From: Paul Quantrill [REDACTED]
Sent: 10 May 2018 21:26
To: Andrew Wood
Subject: Re: AW/85/18/HH - 54 Kingsway

AW/85/18/HH - 54 Kingsway

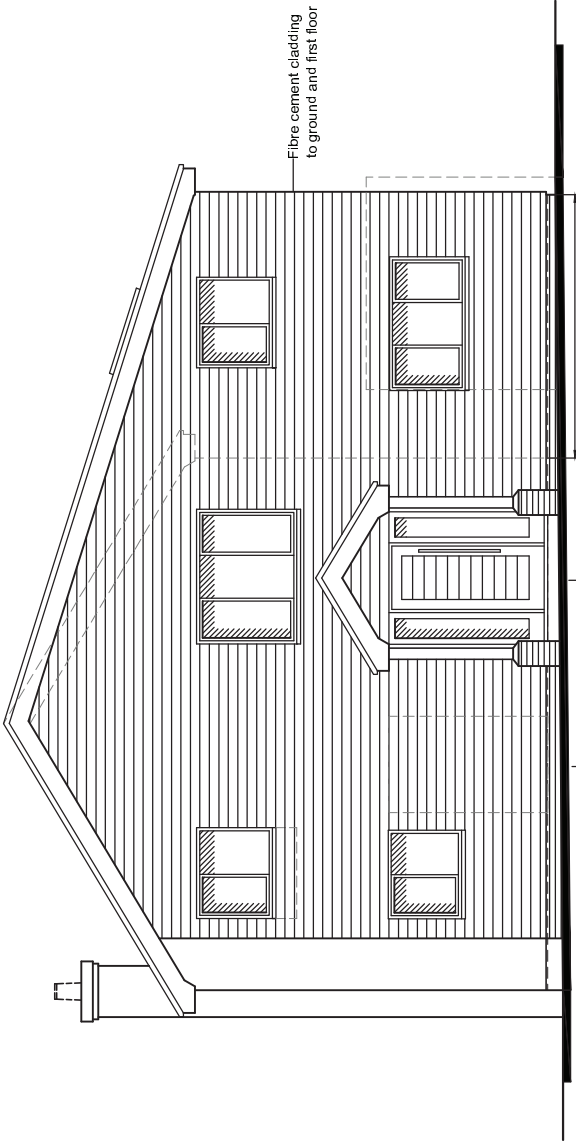
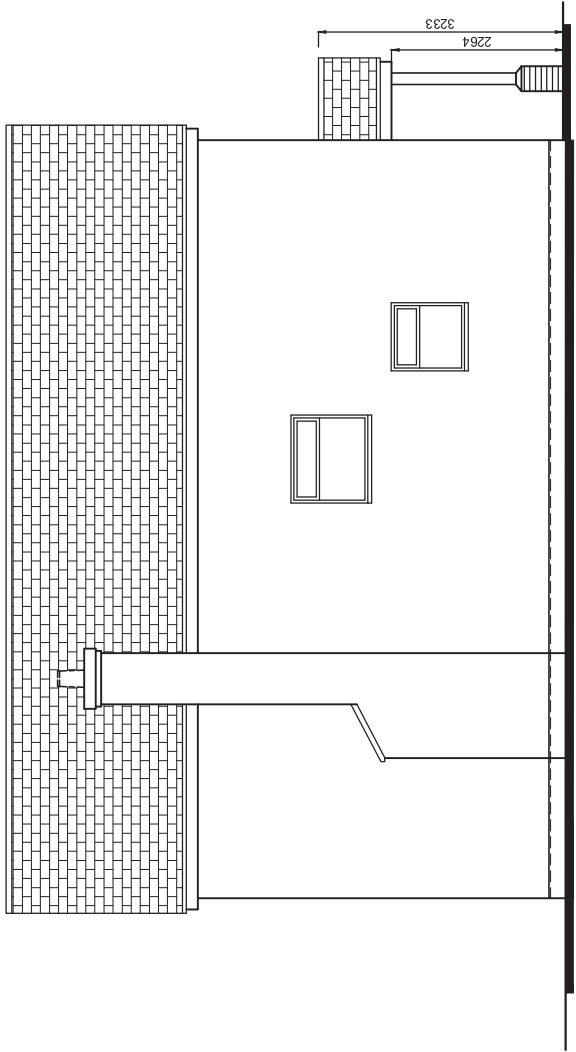
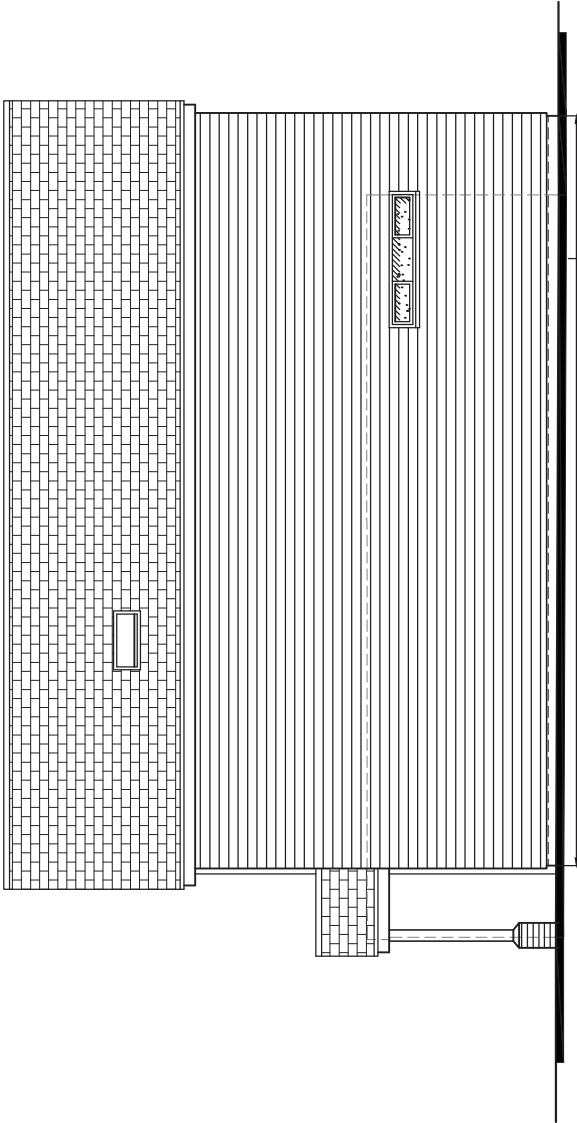
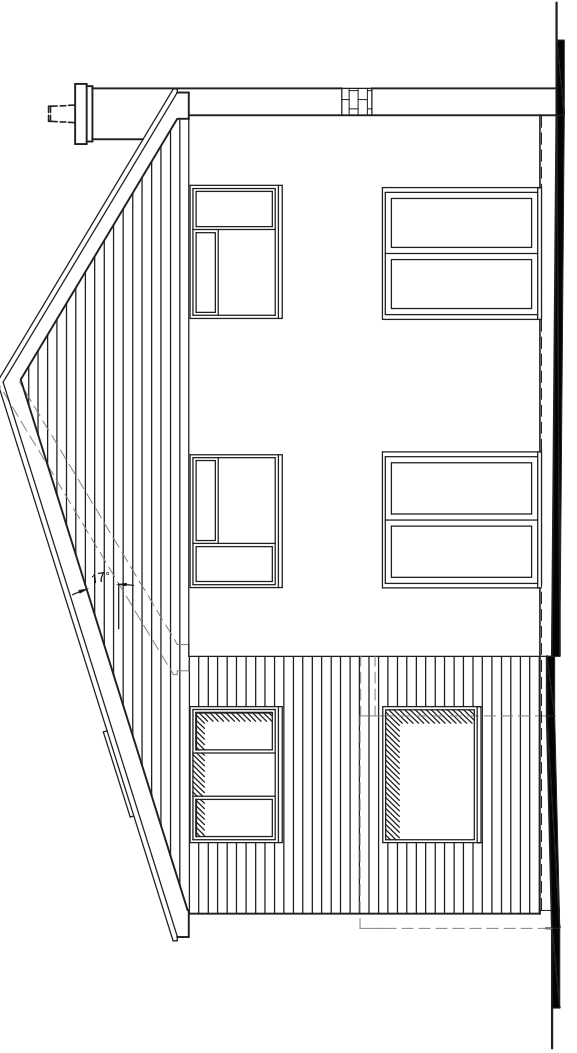
Can you confirm if the intention is to clad the entire house with cement board or to leave the East and South elevations tile hung as existing.

My client only wanted to clad the areas hatched on the elevations as the rest will remain as existing.
